Joint Eastern Arun Area Committee

18 July 2017

Planning Application A/84/17/PL

The Joint Eastern Arun Area Committee (JEAAC) Highways and Transport Sub Group recently reviewed the above planning application.

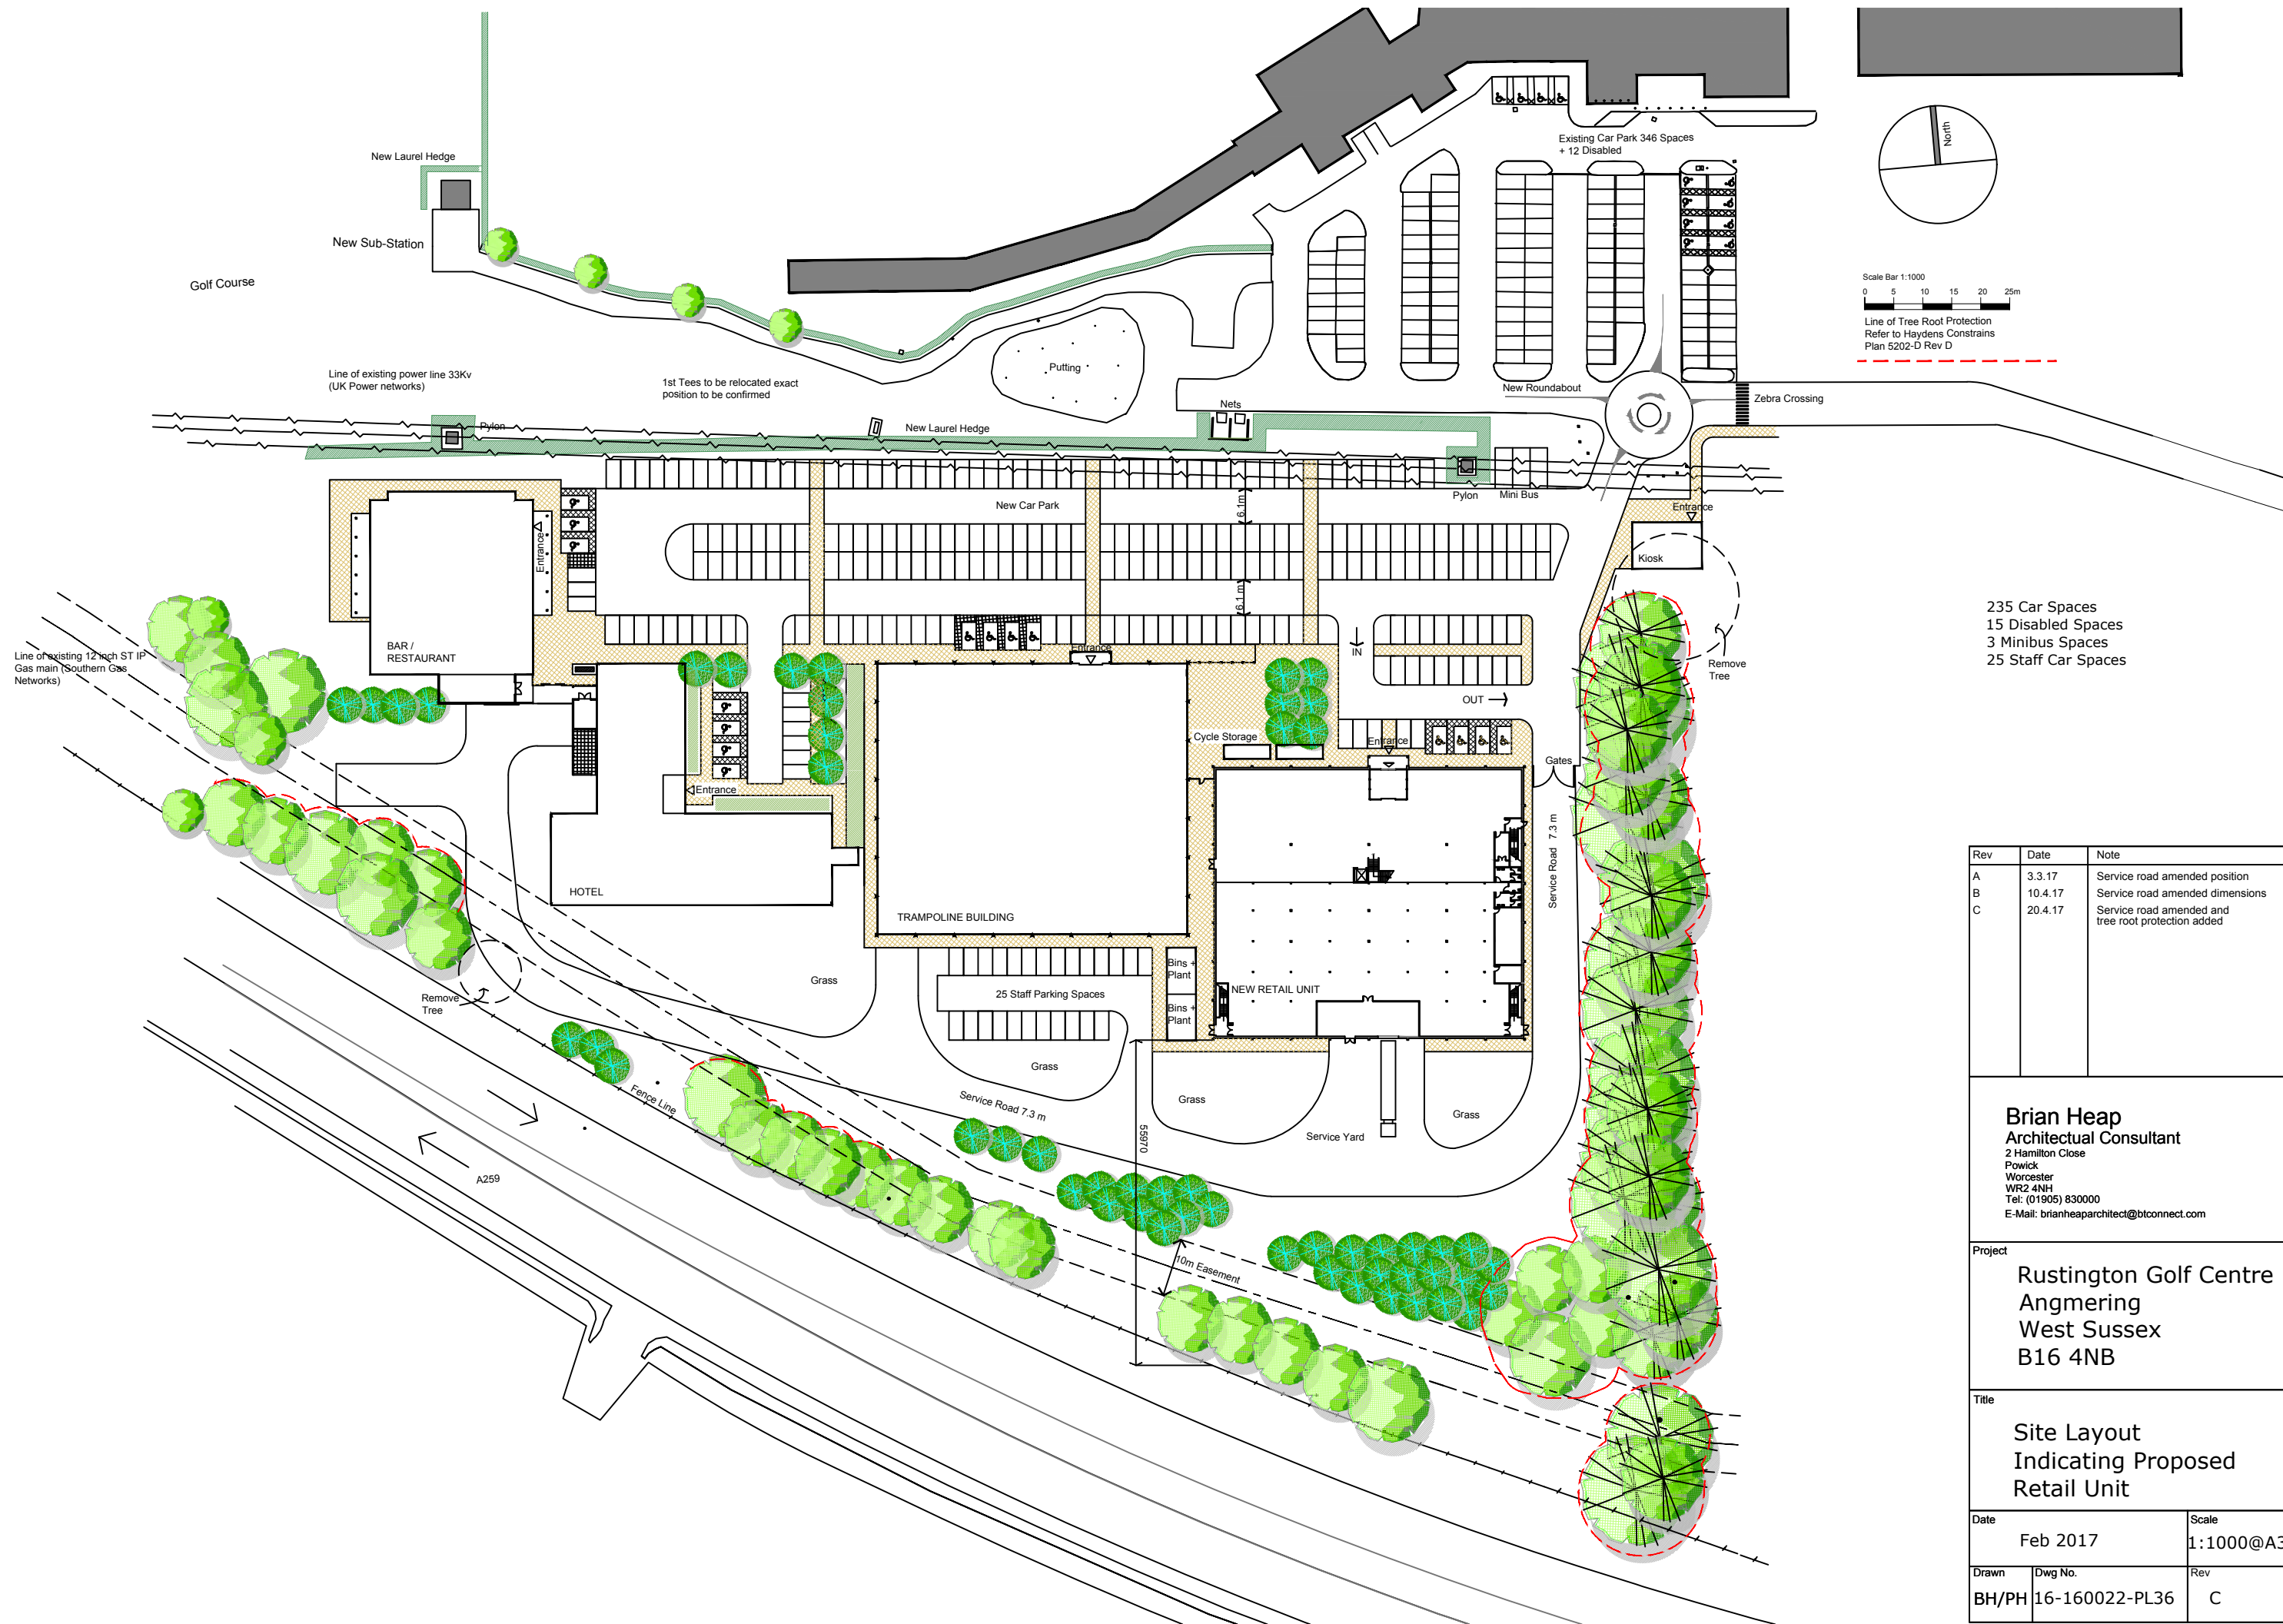
Members of the Sub-Group expressed their severe concern that this application would result in a major increase in traffic activity in the vicinity to the detriment of road users. It was also felt that the internal road configuration would need to be widened to cope with the increased traffic volume entering and leaving the site

I therefore wish it to be included that JEAAC have concern in respect of the traffic flow problems that the increased use of the access from the roundabout would cause for highway users, and concern over the road width and capacity within the site.
